Subject: SSD-9683 - Change Of Use - Educational Establishment
Lots 14 & 15 Sec L DP 8993
7 James Street, ARGENTON NSW 2284

Thank you for the opportunity to comment on the proposed change of use to an Educational Establishment on the above property. Council has reviewed the Environmental Impact Statement (EIS) and the following comments are provided for your consideration:

Site Plan

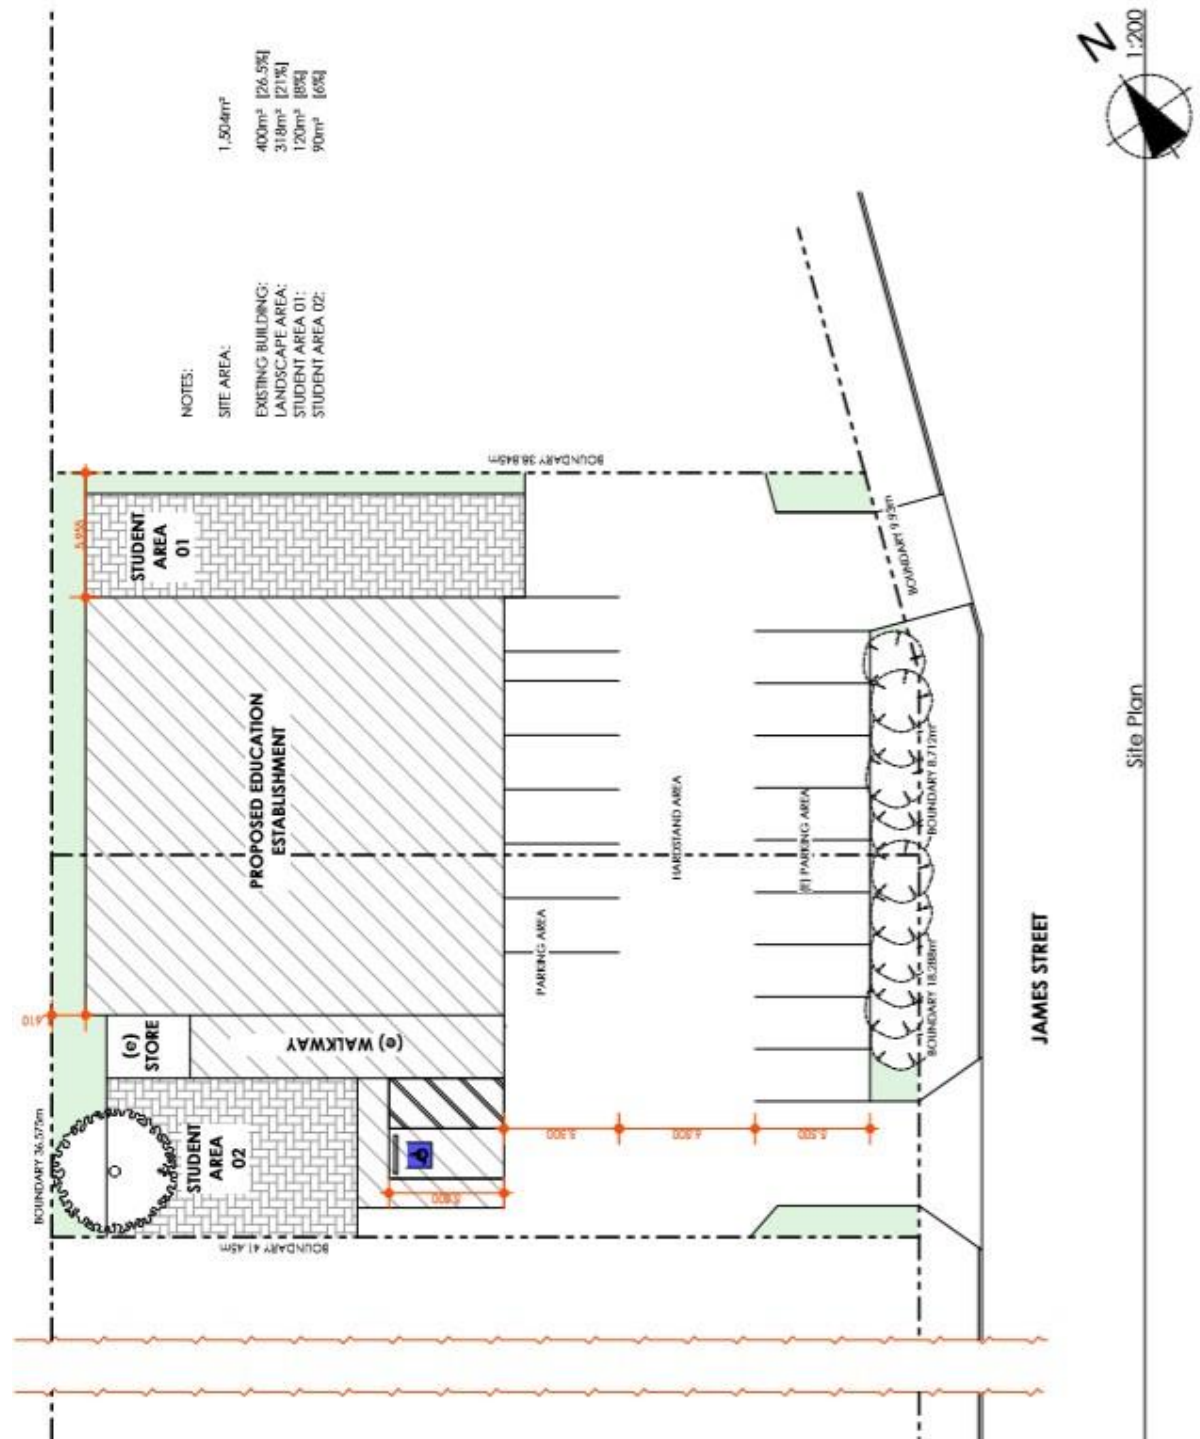
The EIS states that the proposal does not involve building works; however, the Floor Plan prepared by Den-Ad Design & Co in support of the development has a different internal layout to the approved plan for the existing community facility under DA 2456/2007.

Changes to the configuration of a room, whether by removal of an existing wall, partition or other means are not exempt from development approval under State Environmental Planning Policy (Exempt and Complying Development Codes) 2008. Clarification is required as to why building modification is not included in the proposal. If any unauthorised works exist on the site, they will need to be formalised via a building certificate prior to the use of the premises.

The proposal is deficient in outdoor space for the students. There are two small outdoor areas, totalling just 210m². For the 80 students proposed, this is approximately 2.6m² per student. (It is important to note that under the National Quality Framework for child care centres, they are required to provide a minimum of 7m² of unencumbered space per child.)

Both outdoor spaces are bordered by 1800mm Colorbond fence which is a harsh and unsympathetic boundary definition. Minimum 1m wide planting areas are recommended for the establishment of soft landscape including trees that provide amenity, outlook, shade and create an attractive and pleasant learning environment.

The location of the existing tree to the rear is to be accurately identified and the landscape design should cater for the long-term viability of this tree.

It appears that the proposed disabled car park could be located in line with existing car park bays, allowing further space to be recovered for outdoor learning space.

The stormwater from the site drains into a pit in the northern corner. Two of the outlets from this pit are directed towards the adjoining property to the rear (140 Montgomery St). It is recommended that legal rights to drain over this property be demonstrated.

Figure 6 | Proposed Landscaping and Fencing Plan (Source: Applicant's RtS)

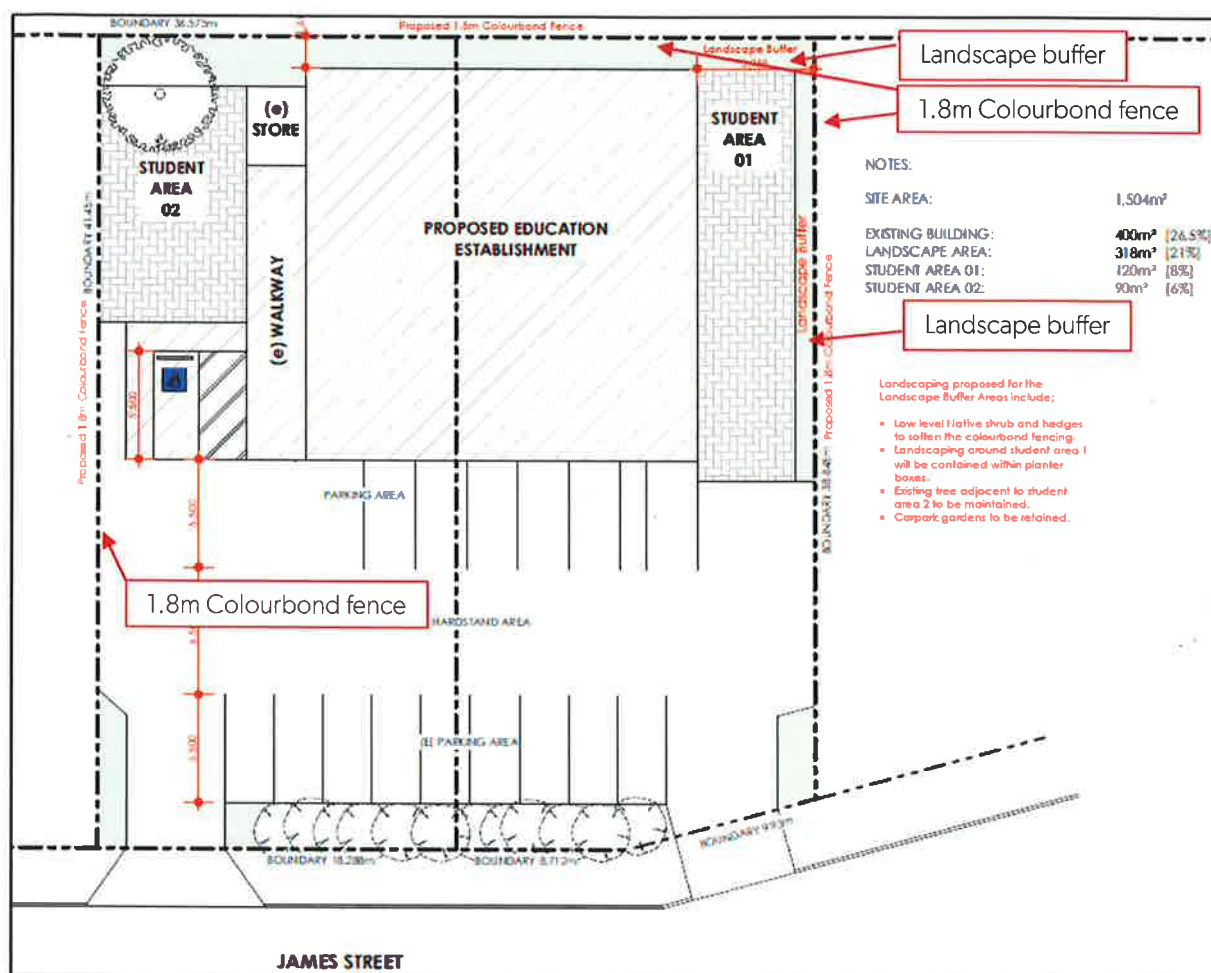
No detailed site-wide landscape strategy has been provided as per the NSW Government Planning Secretary's Environmental Assessment Requirements. The area allocated for landscape planting is approximately 10.6% of the site. Given the importance of external learning spaces to wellbeing and outlook from the school building, a Landscape Plan addressing the design quality principles in SEPP 2017 is required to demonstrate how the landscaping compliments the site as a learning environment. In this regard, it is noted that the site has limited capability to accommodate adequate landscaping.
